# Planning Inspectorate

EN010158

15 December 2025

### Application by Rosefield Energyfarm Limited for an order granting development consent for the Rosefield Solar Farm

Base map and data from Ordnance Survey © Crown Copyright and database right

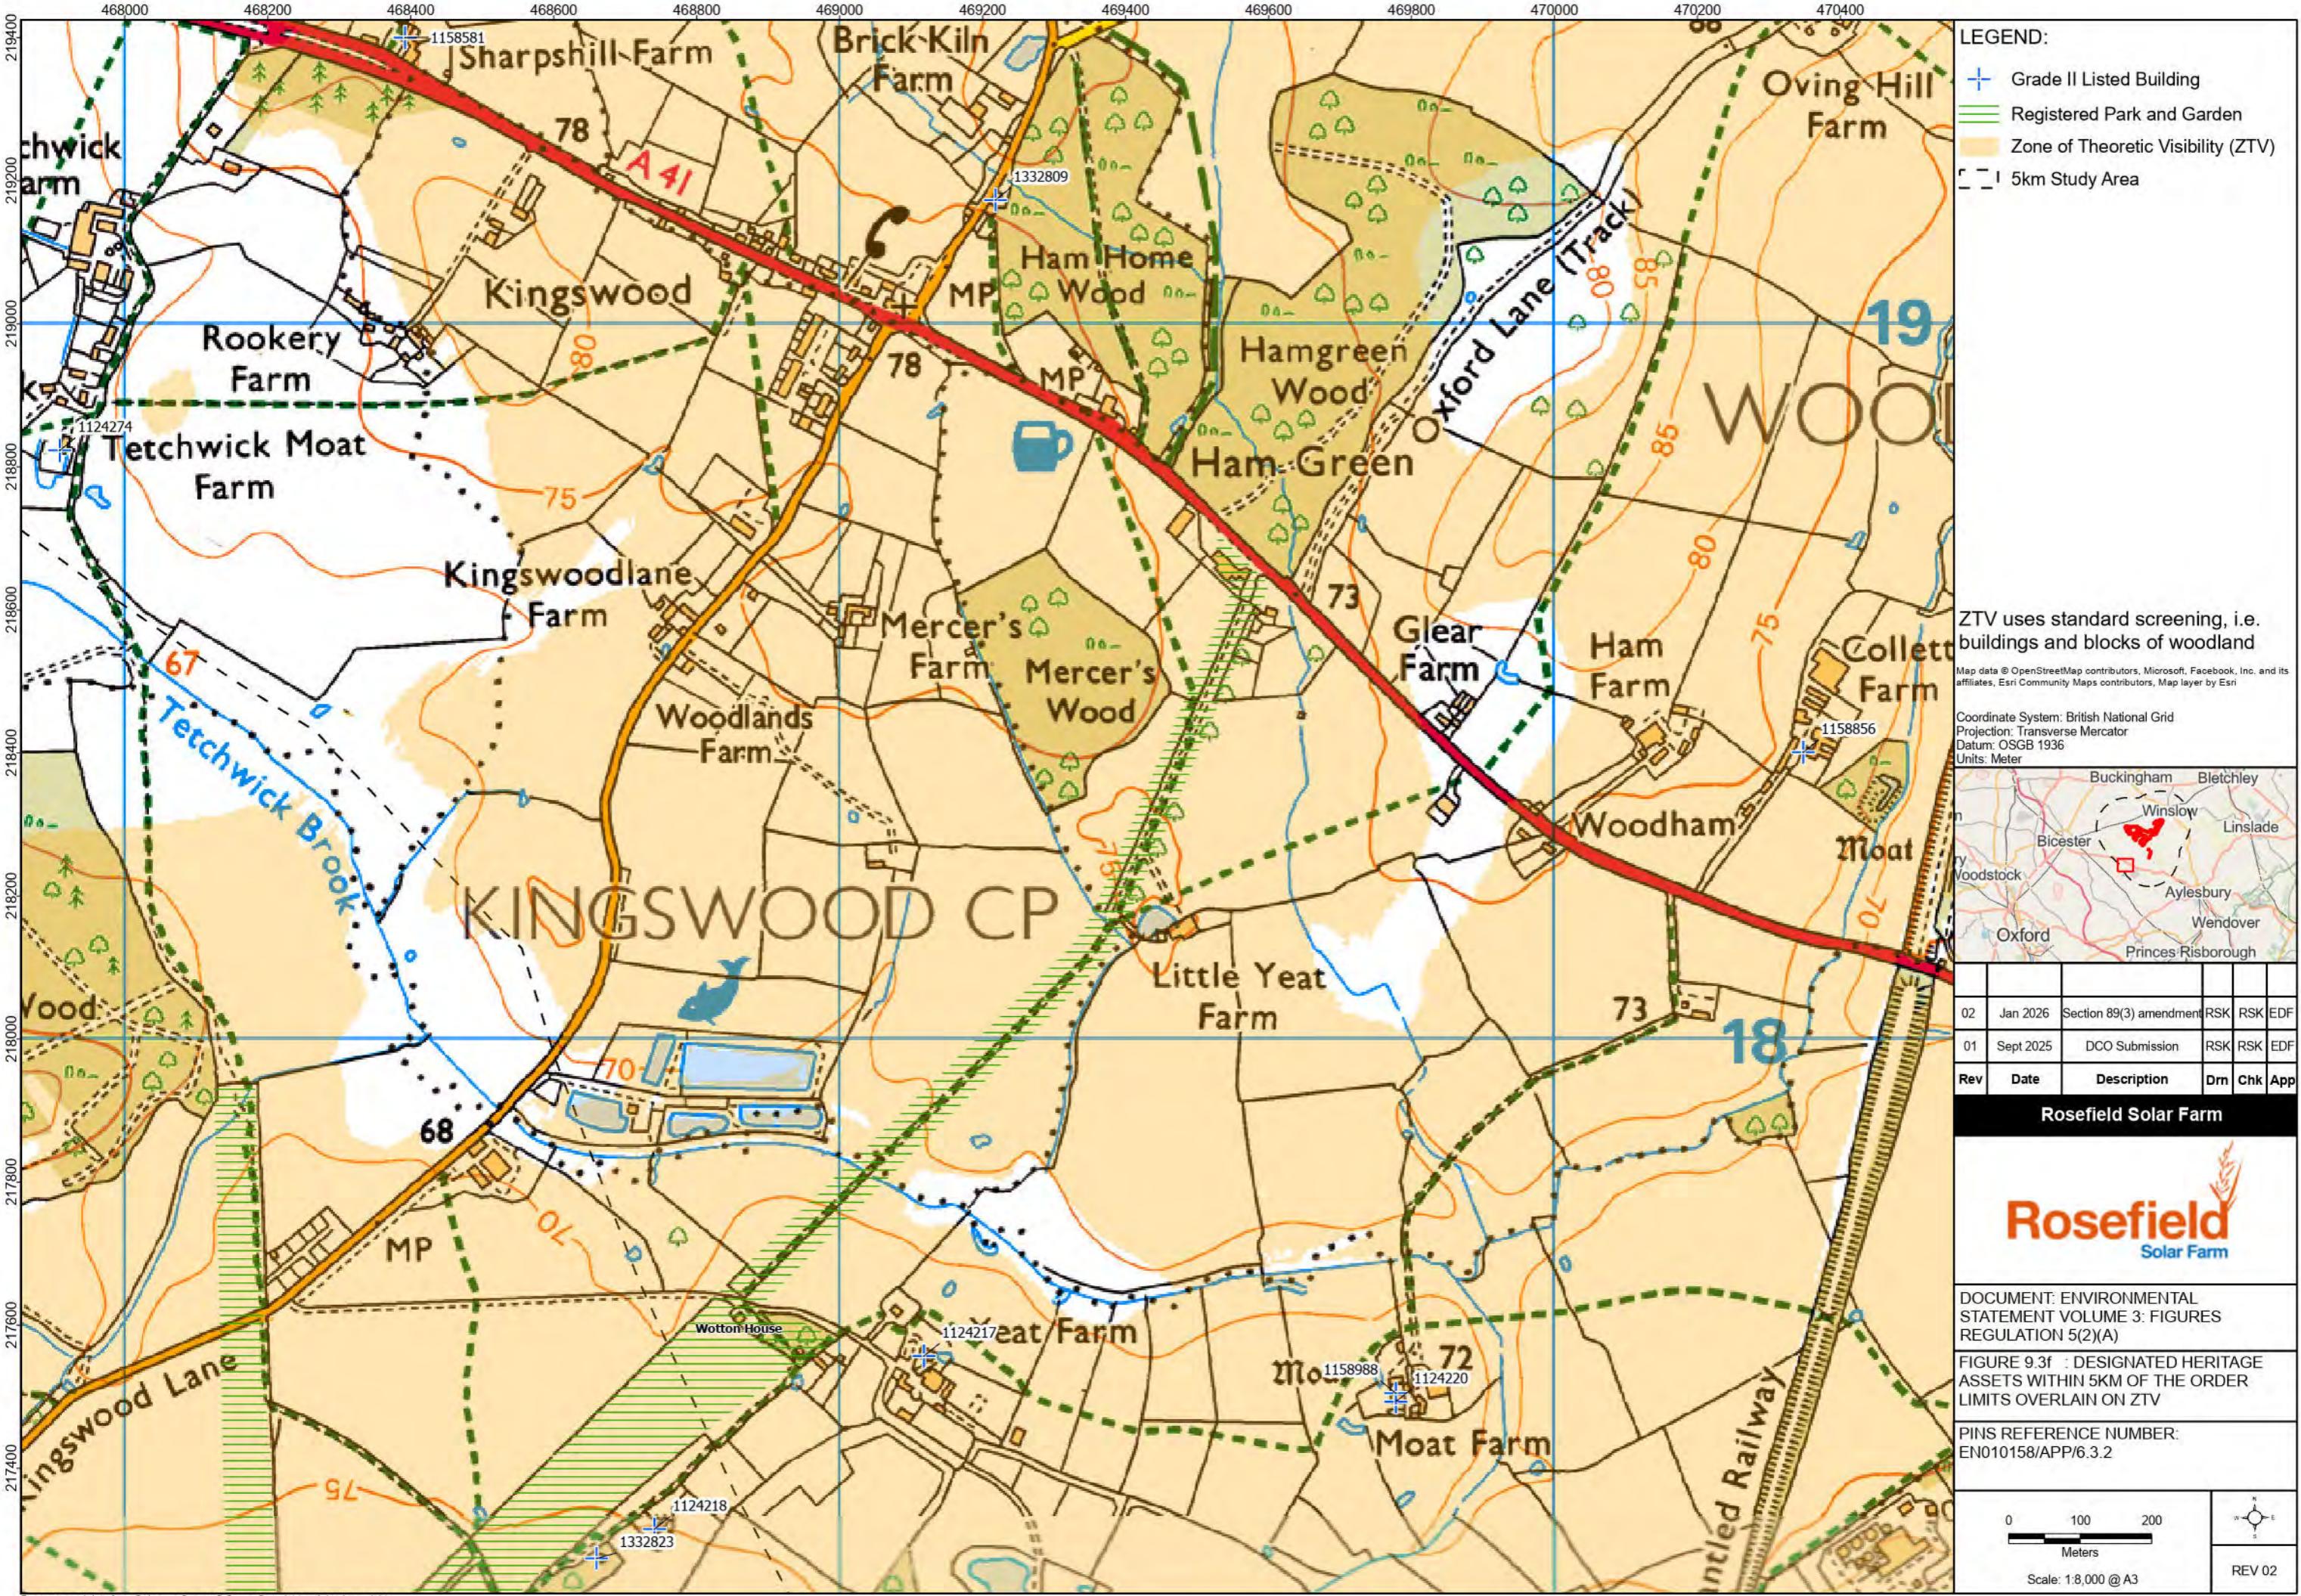
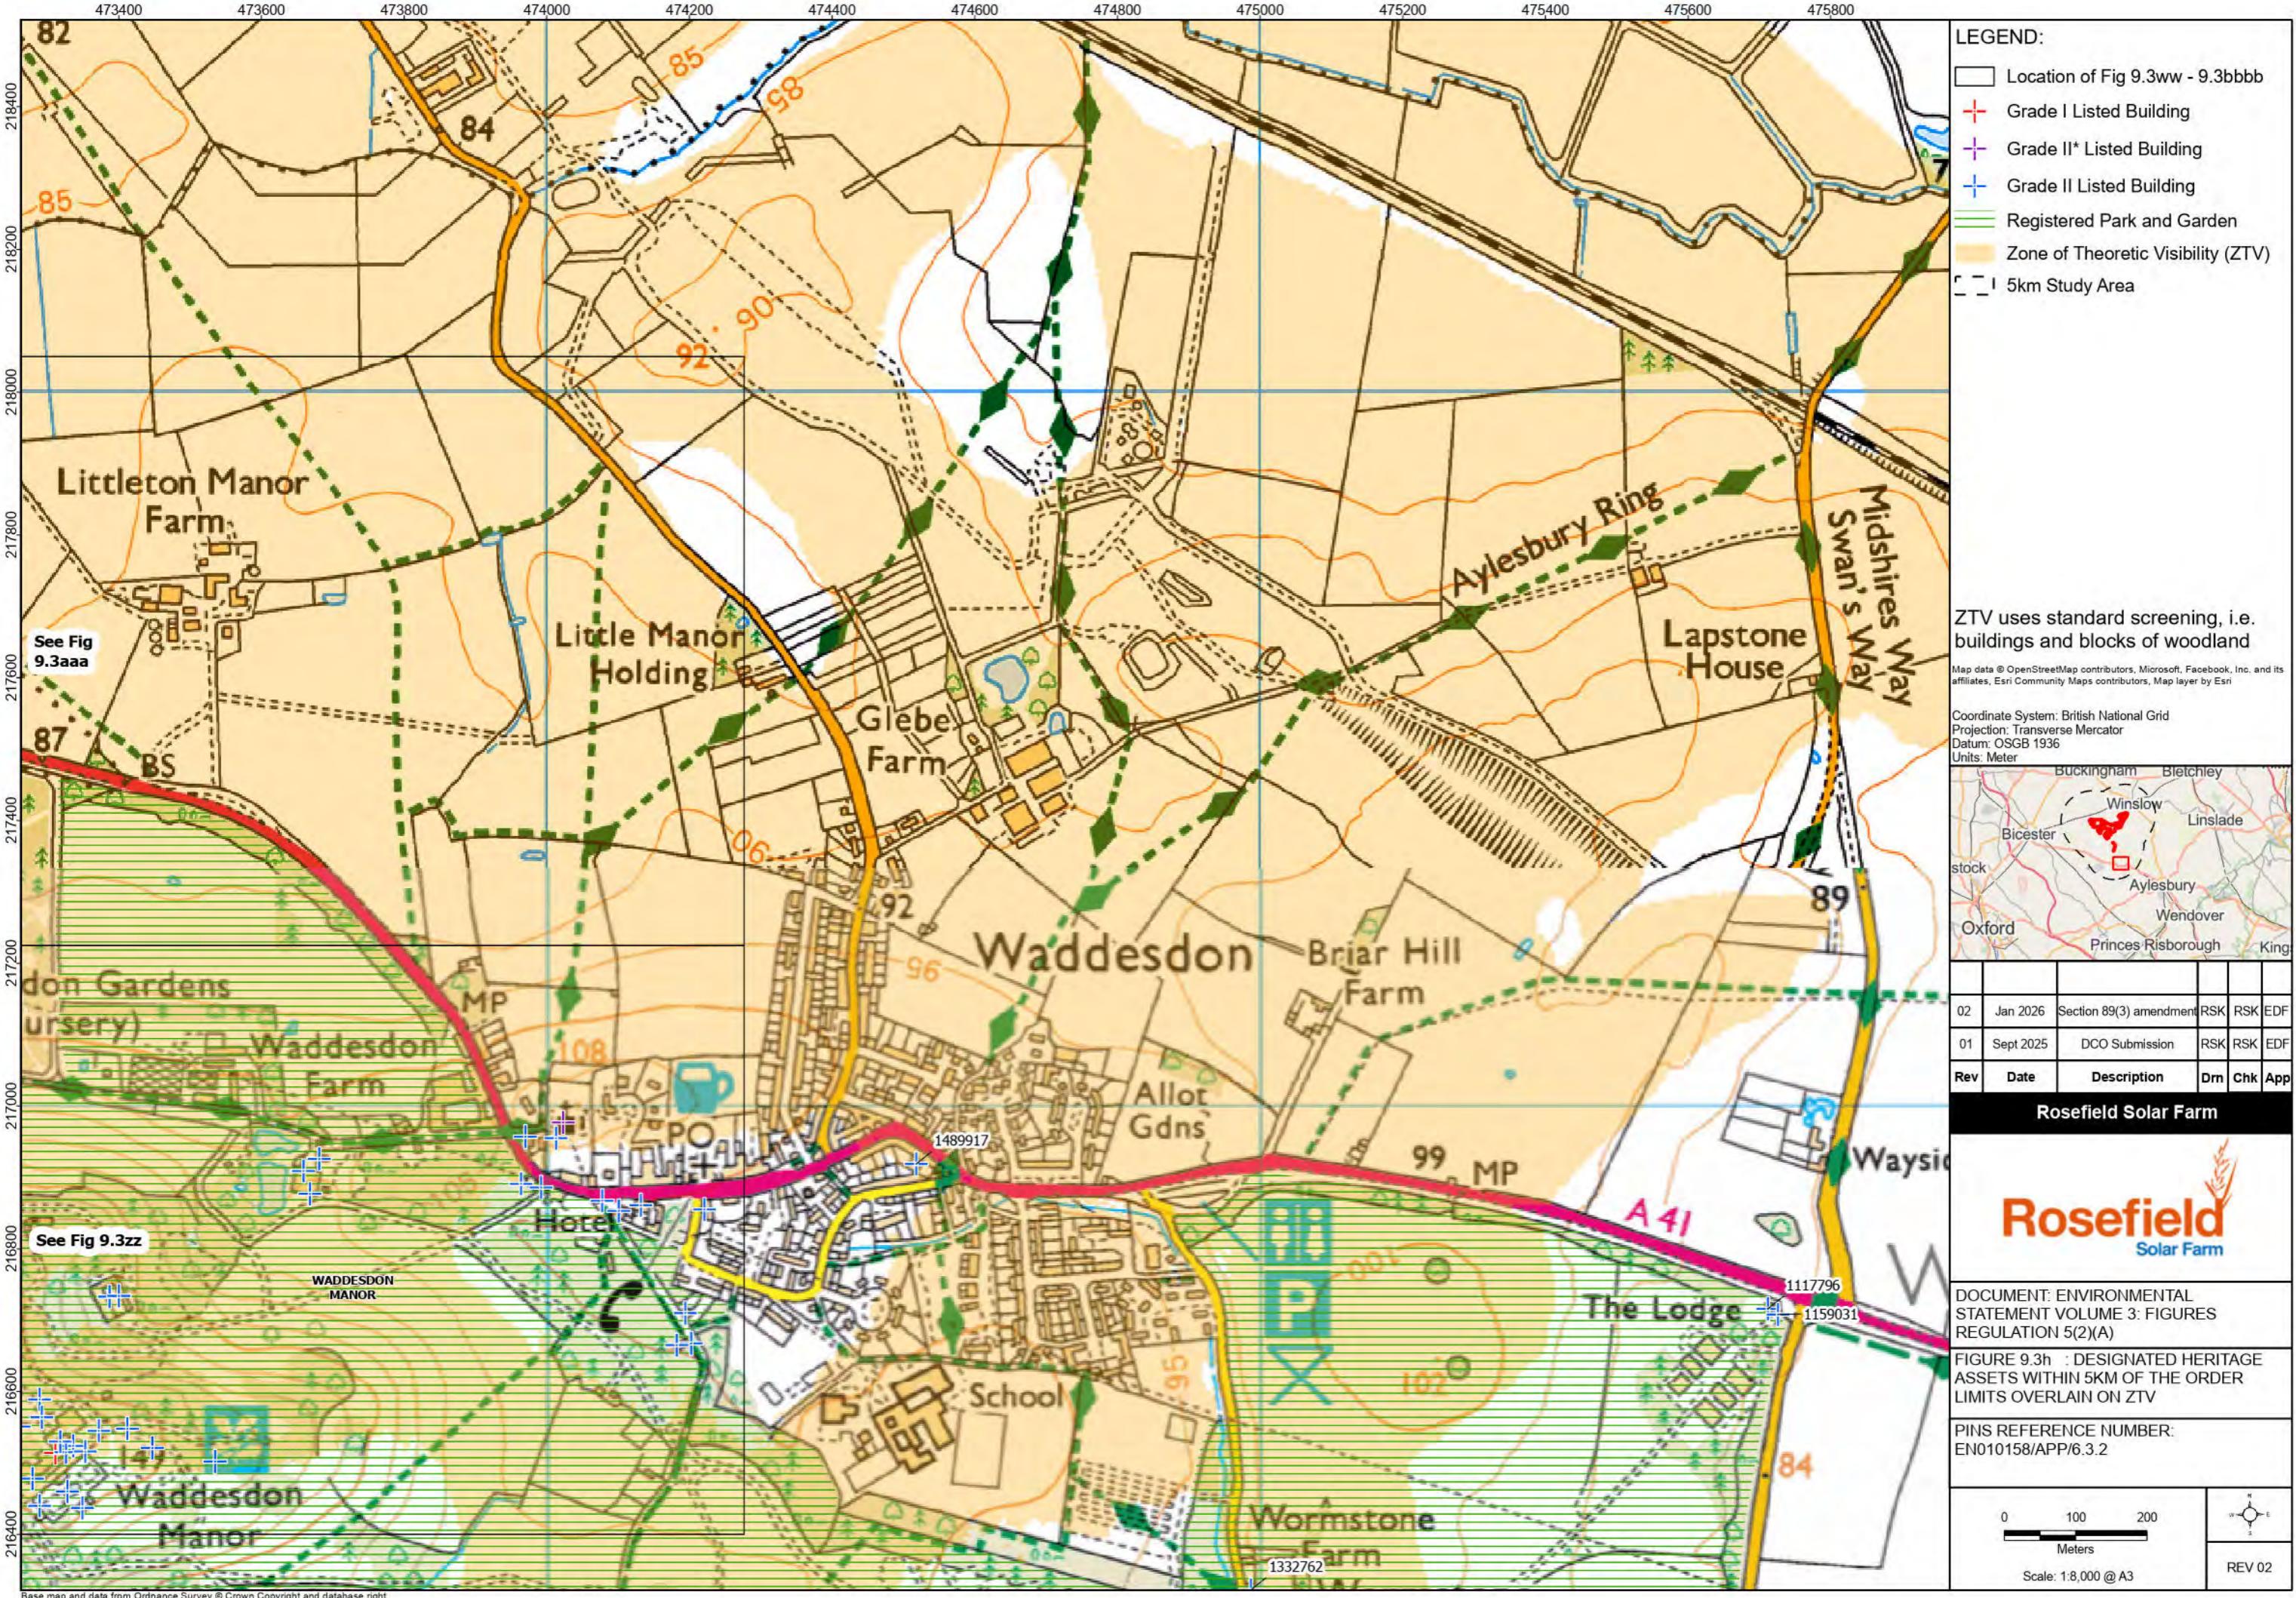
In addition, in ES Chapter 9: Cultural Heritage Figures [APP-068], the labelling of heritage assets is absent or unclear across the majority of cultural heritage figures. For example, the labelling of listed buildings within villages in figure 9.4 is unclear. Information provided in the legend for the figures is also sometimes incomplete. Review and update the figures to ensure that they are legible and can be easily cross-referenced with the assessment in ES Chapter 9: Cultural Heritage [APP-052].
